Application No: LU/72/25/OUT
Site Address: Land to the West of New Courtwick Lane Wick BN17 7RZ
Description of works: Hybrid Planning Application comprising of the following: 1) - Outline application with all matters reserved (except access) for Phase 2 (West of Site) comprising development of approximately 8,800sqm GIA Light Industrial/Storage and Distribution (Use Class E(g)(iii) / B8), and 2) - Full Application for Phase 1 (East of the Site) for a food store (Use Class E(a)), 2 No. Drive-Thru food/beverage units (Sui Generis) with revised vehicular access, associated parking and landscaping. This application may affect the setting of a listed building and is in CIL Zone 2 and is CIL Liable.

This application was considered by the Littlehampton Town Council's Planning and Transportation Committee on Monday 19 May 2025. The committee objected to the application, an extract of the minutes of the meeting is set out below:

8.2.1. Planning Application Reference LU/72/25/OUT - Land to the West of New Courtwick Road

Figure 7 - Proposed Site Masterplan

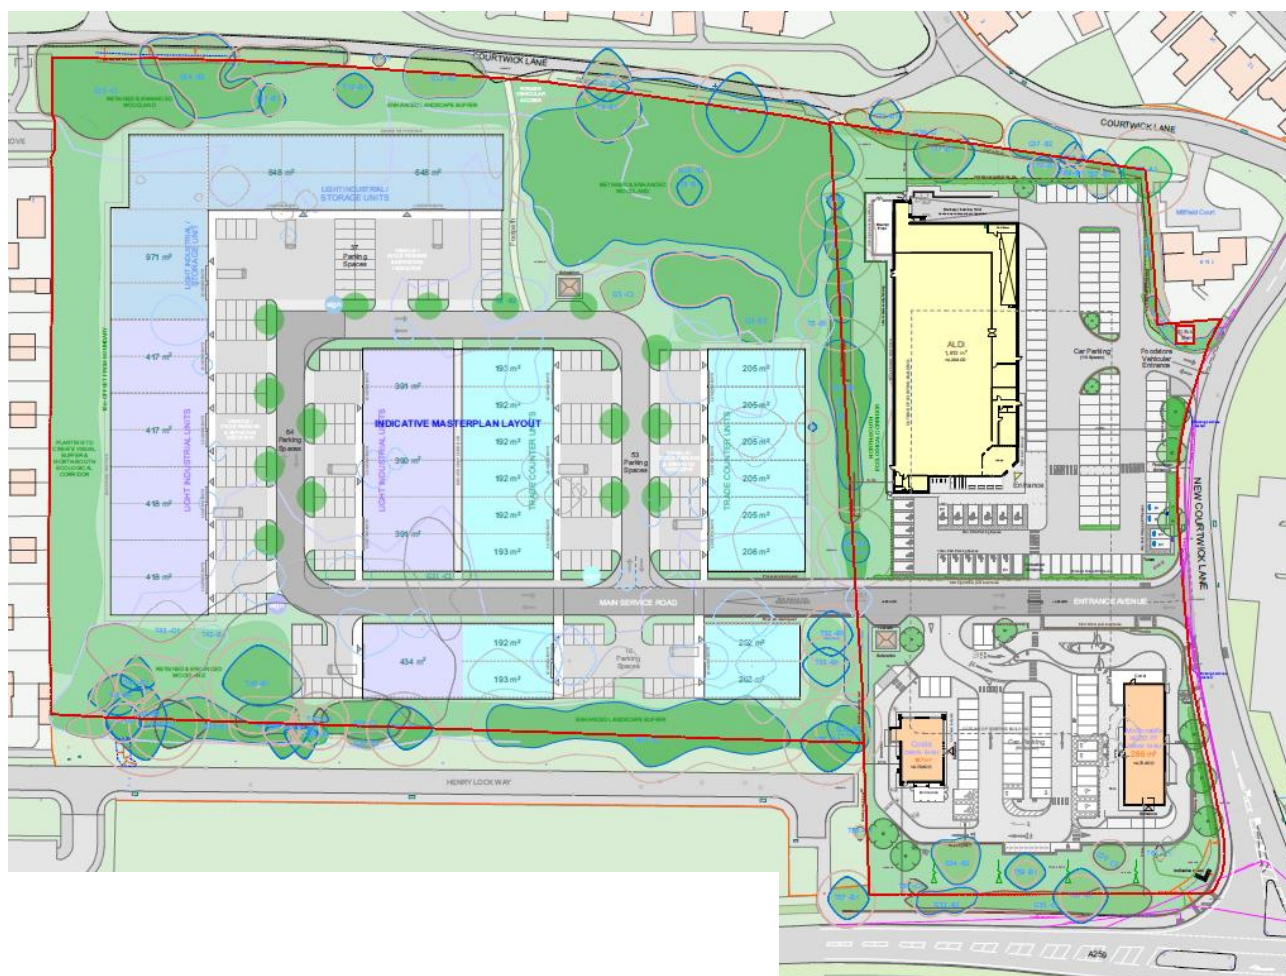
8.2.1.3. Regarding the layout of the site itself, Members considered that the delivery area for the food store needed to be reviewed because of its proximity to Millfield Court. In its current position, it was felt that resident's amenity would be adversely affected by the delivery operation particularly in terms of noise and the hours of operation.
